Construction Drawings_V2.pdf Markup Summary 12-7-2021

EPC Stormwater - Glenn Reese (4)

## C3.1

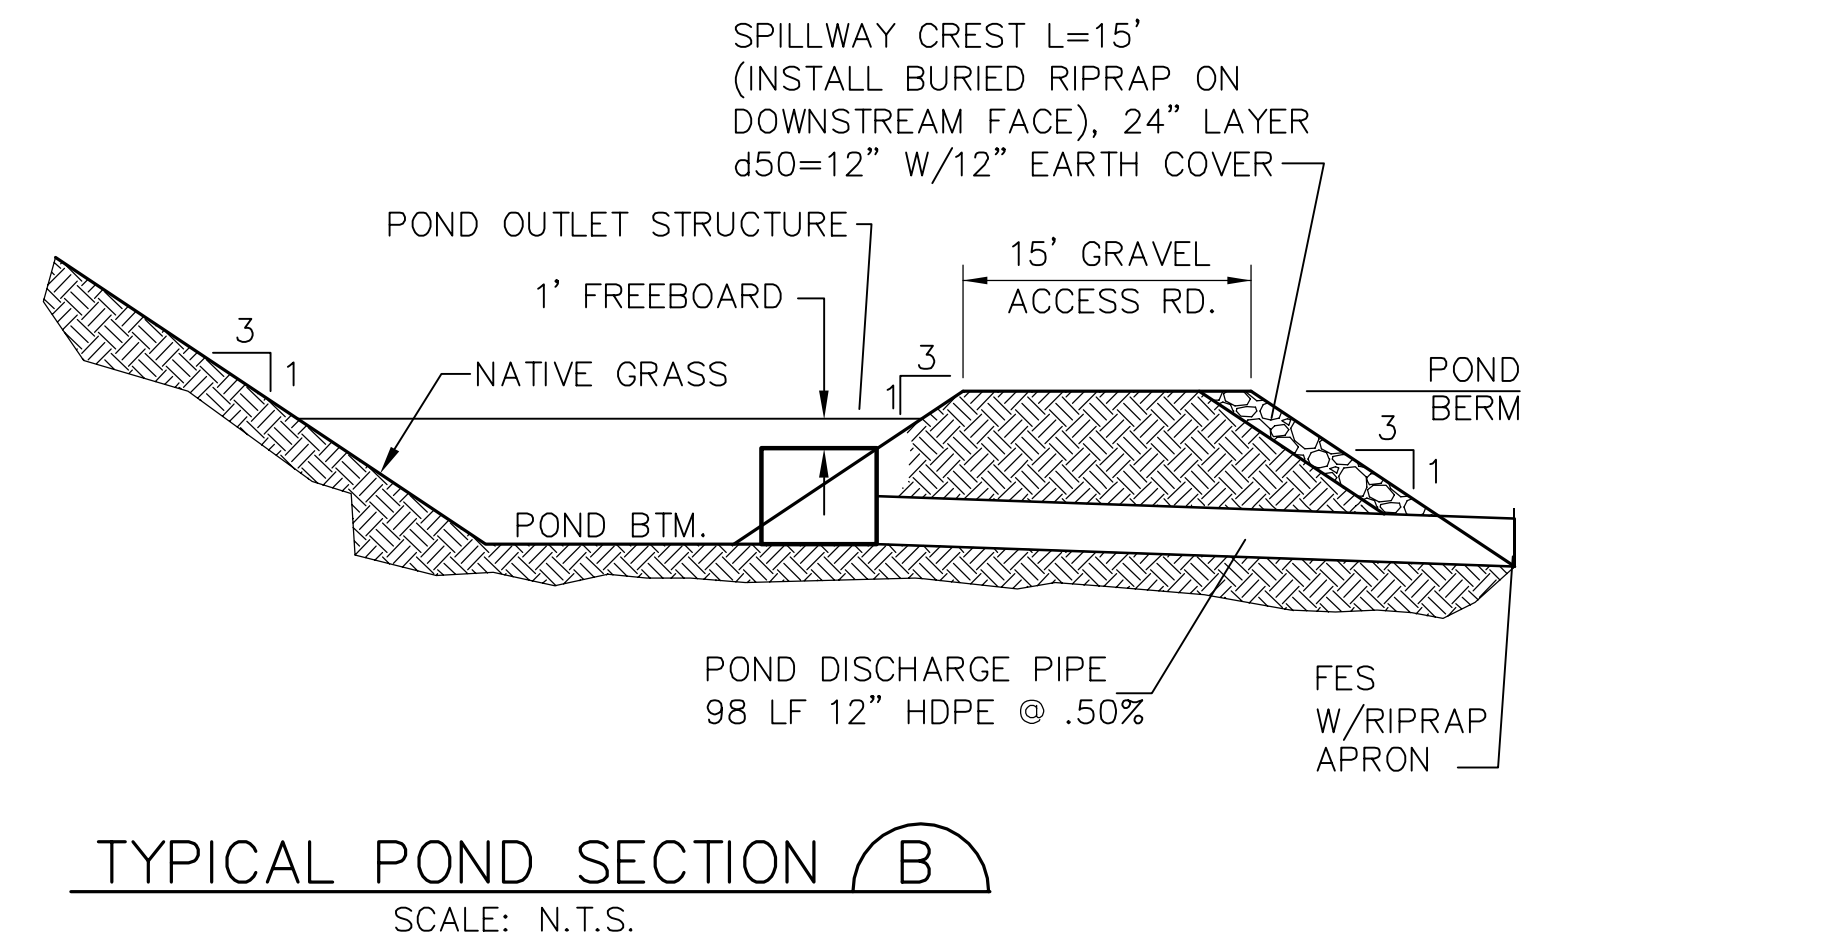
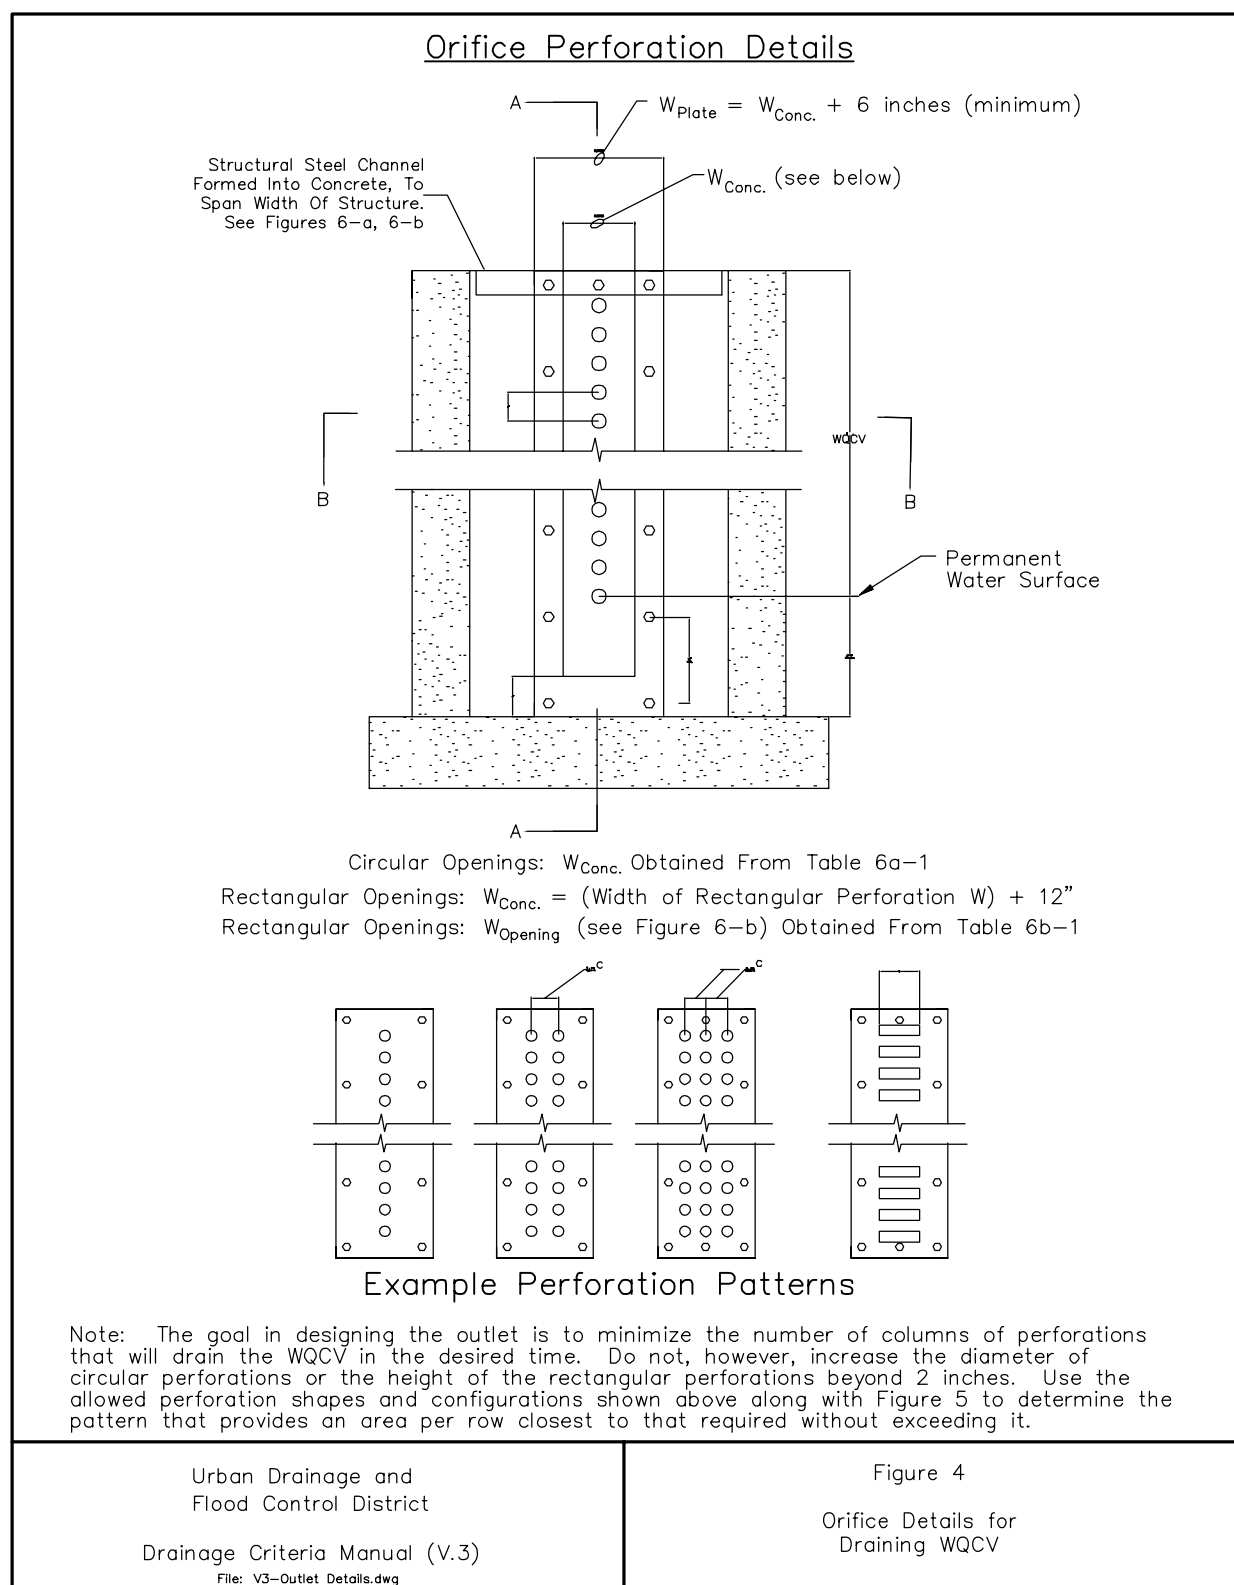
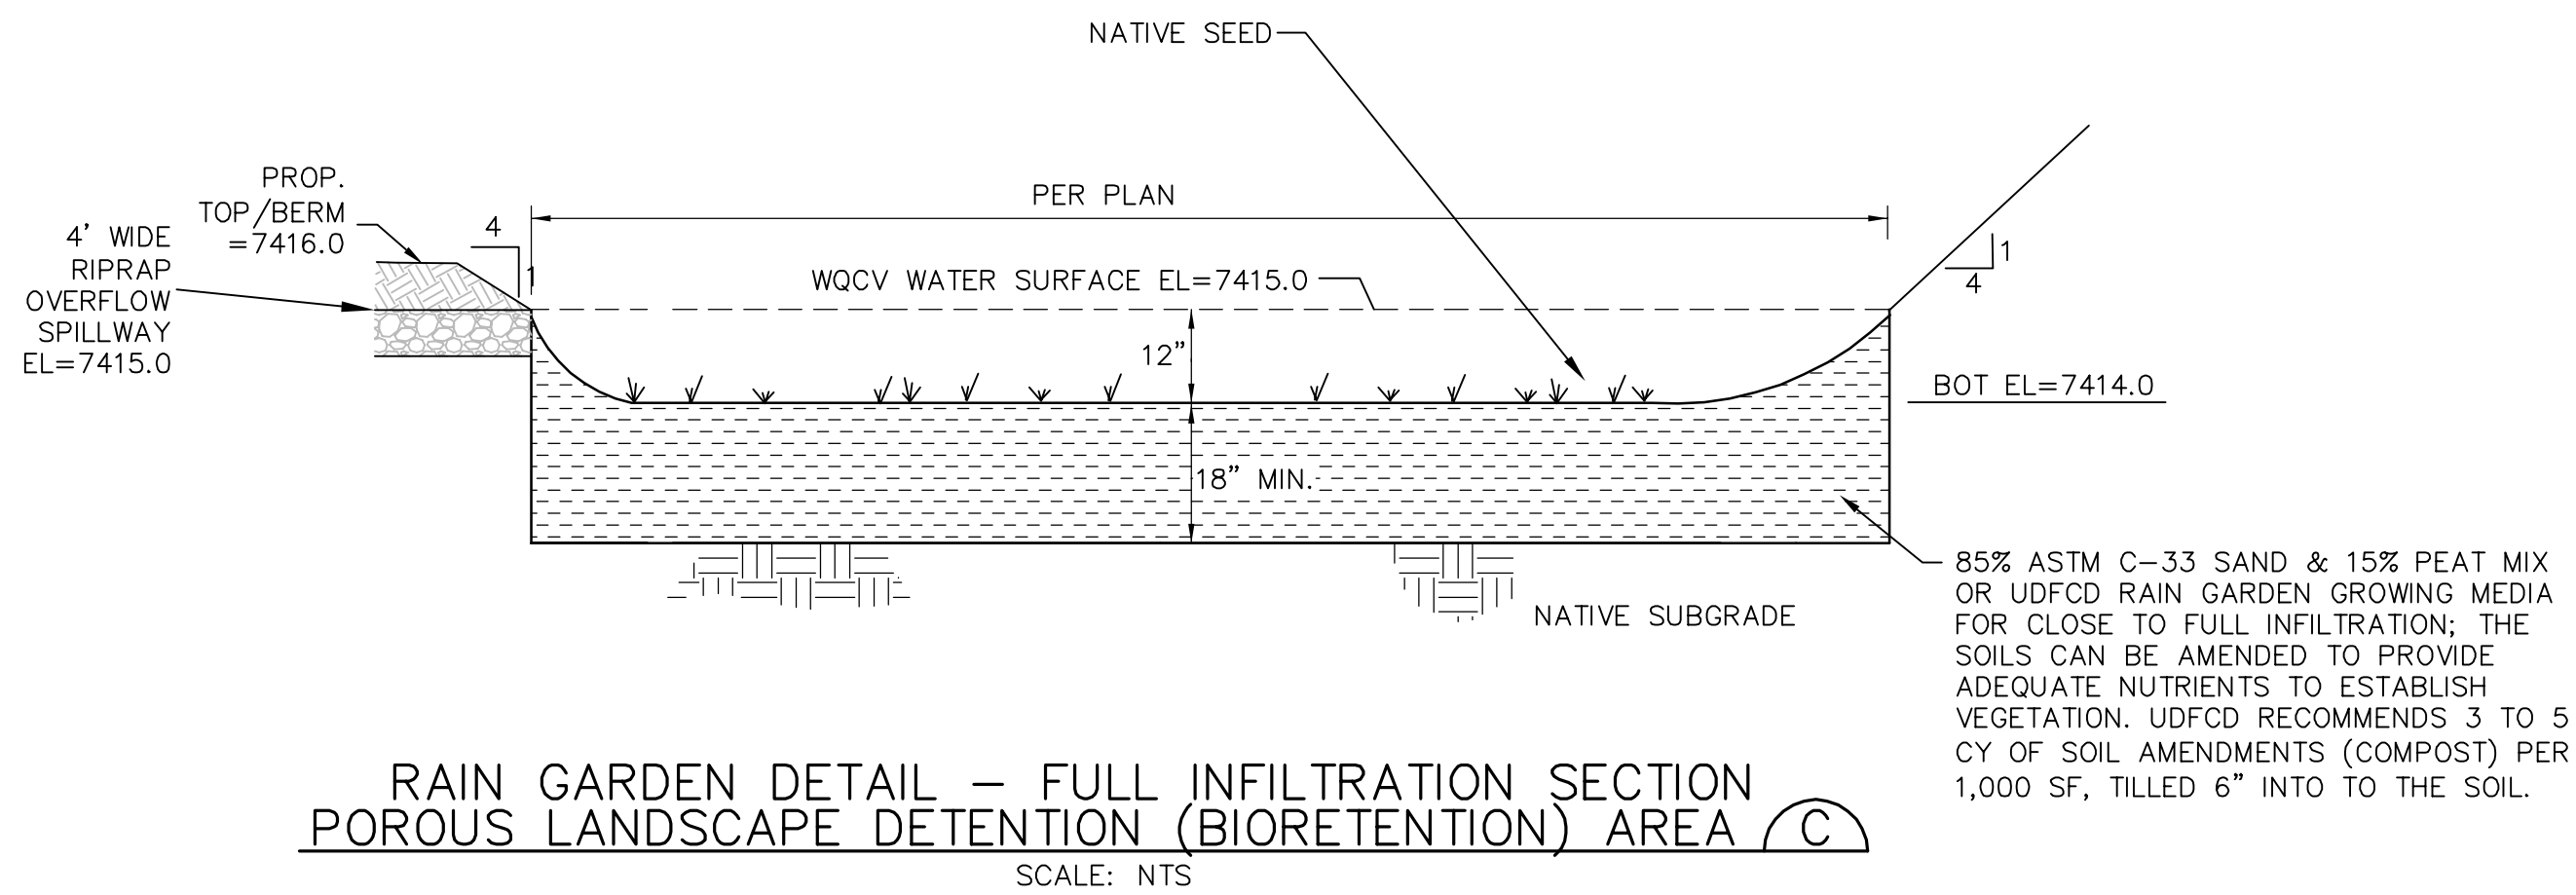
Note on page 96 of the FDR, a well screen is recommended for the orifice diameters specified. This bar-type of trash rack will allow large debris (>1.5") between trash rack and orifice place causing orifice to clog more frequently than a well screen.

Specify installation instructions and mix ratio for soil riprap. As an example, note: "Per MHFD Spec Section 31-37-00, the soil material shall be native or topsoil and mixed with 65% riprap and 35% soil by volume. And soil riprap shall consist of uniform mixture of soil and riprap without voids." And specify the riprap designation per Table 1 of the same spec.

clarify that this ramp is to be gravel.
